Your Ref: OWPC22938
Our Ref: BR/76/19/PL 11-03-2019
Please ask for:
Stuart Corbey

13th May 2019

Conversion of existing house into 2 No. 3 bed semi detached properties.
Alloways 33 Shelley Road Bognor Regis

Proposed Conversion Proposed Plans Planning
Date March 2019
Scale 1:50

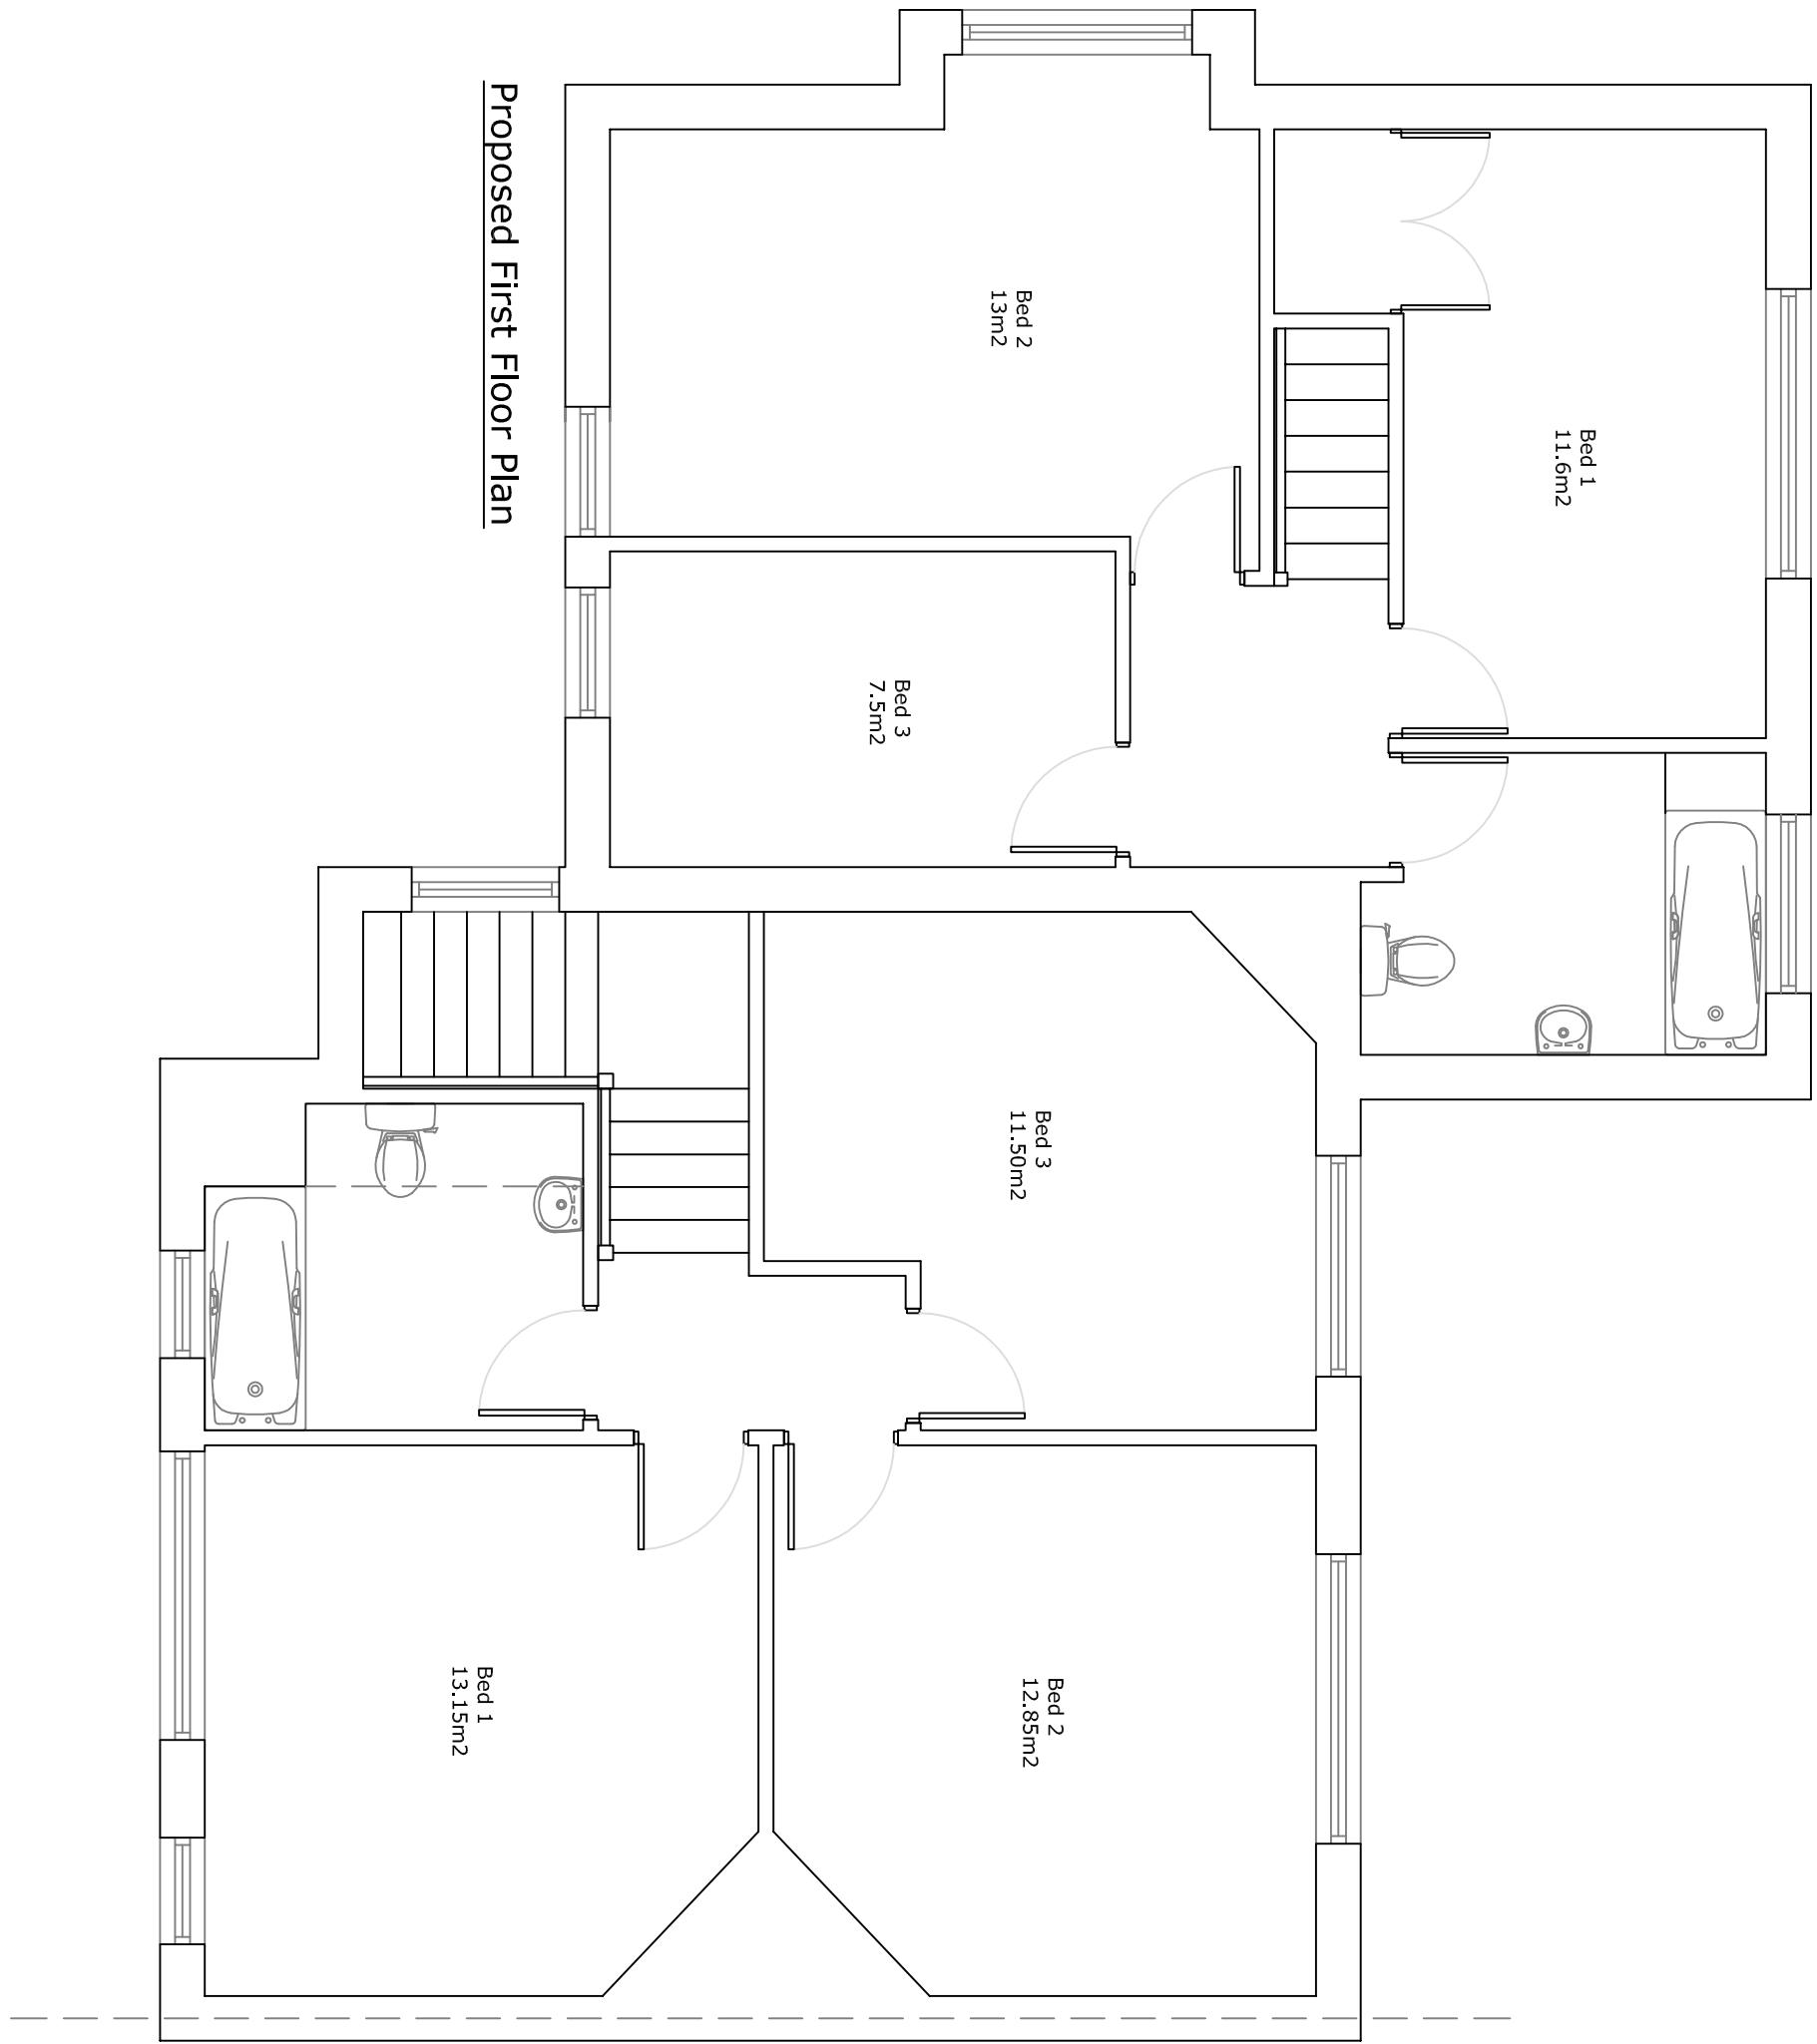
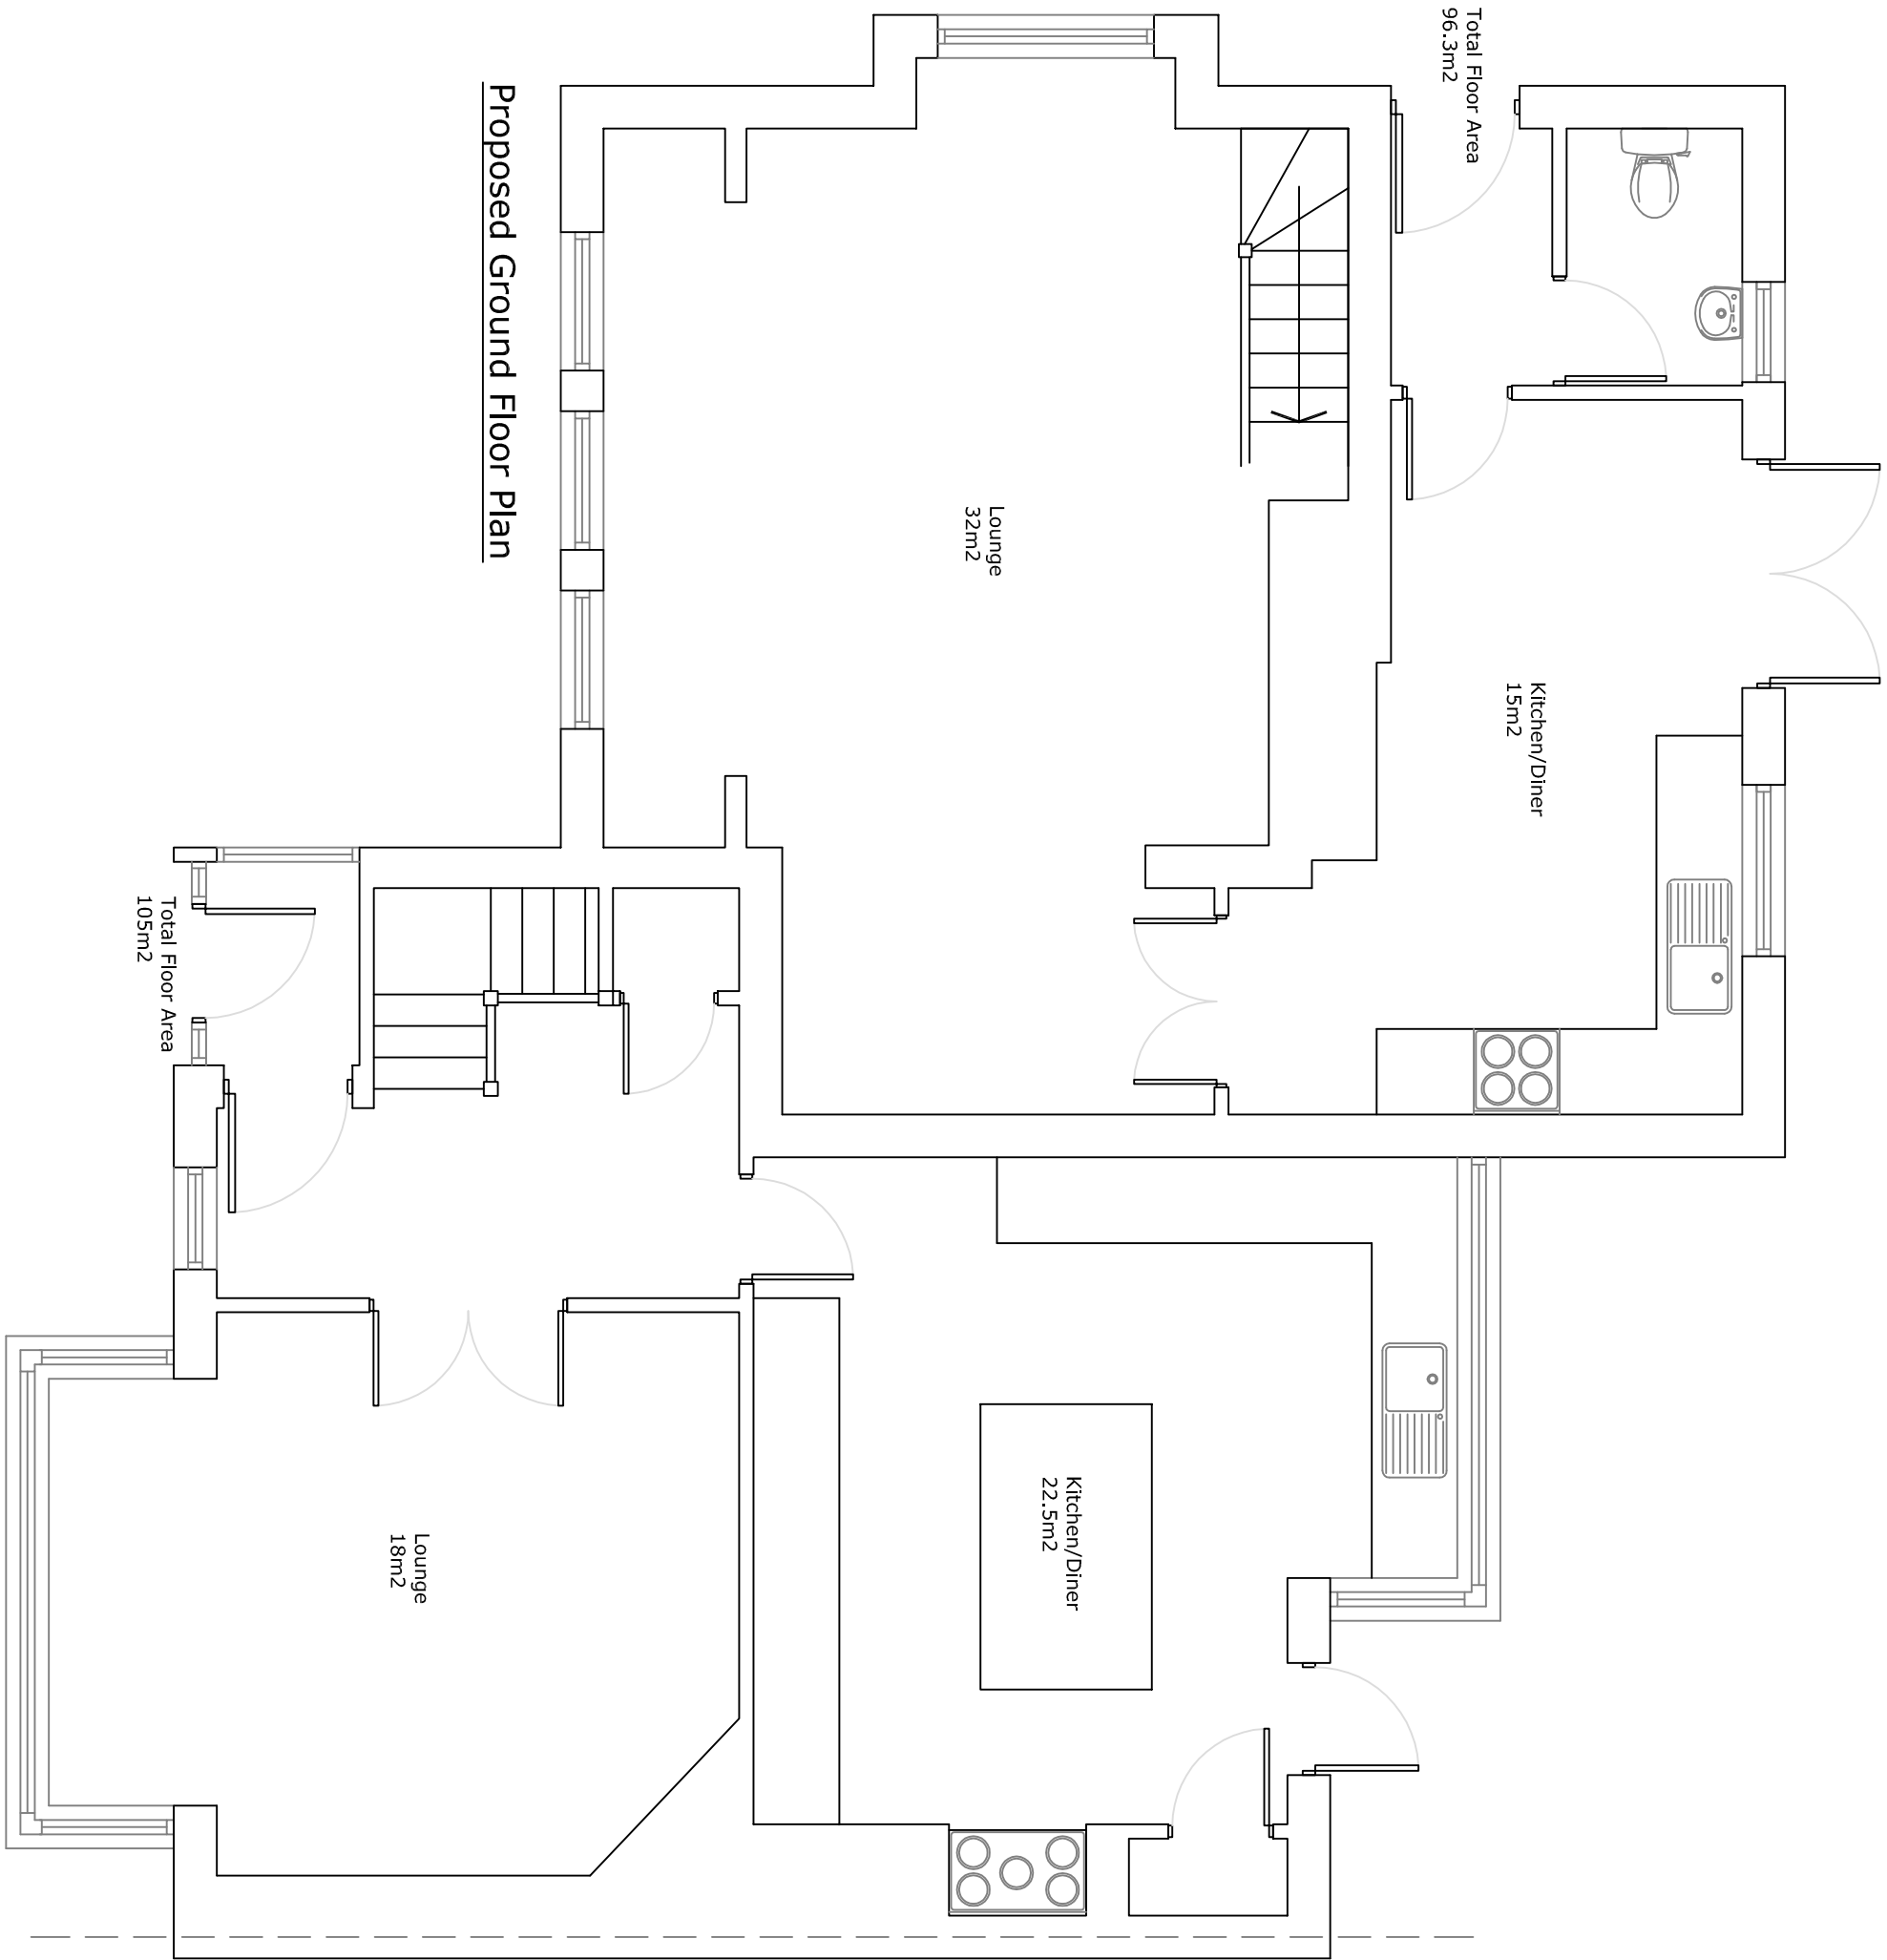
A compromise would be to reduce the size of the first floor extension above the Garden Room so that it is stepped in from the east elevation, creating a smaller third bedroom at the rear, or else exclude the rear bedroom and restrict the conversion to two bedrooms. The first floor bathroom could still be created as proposed.
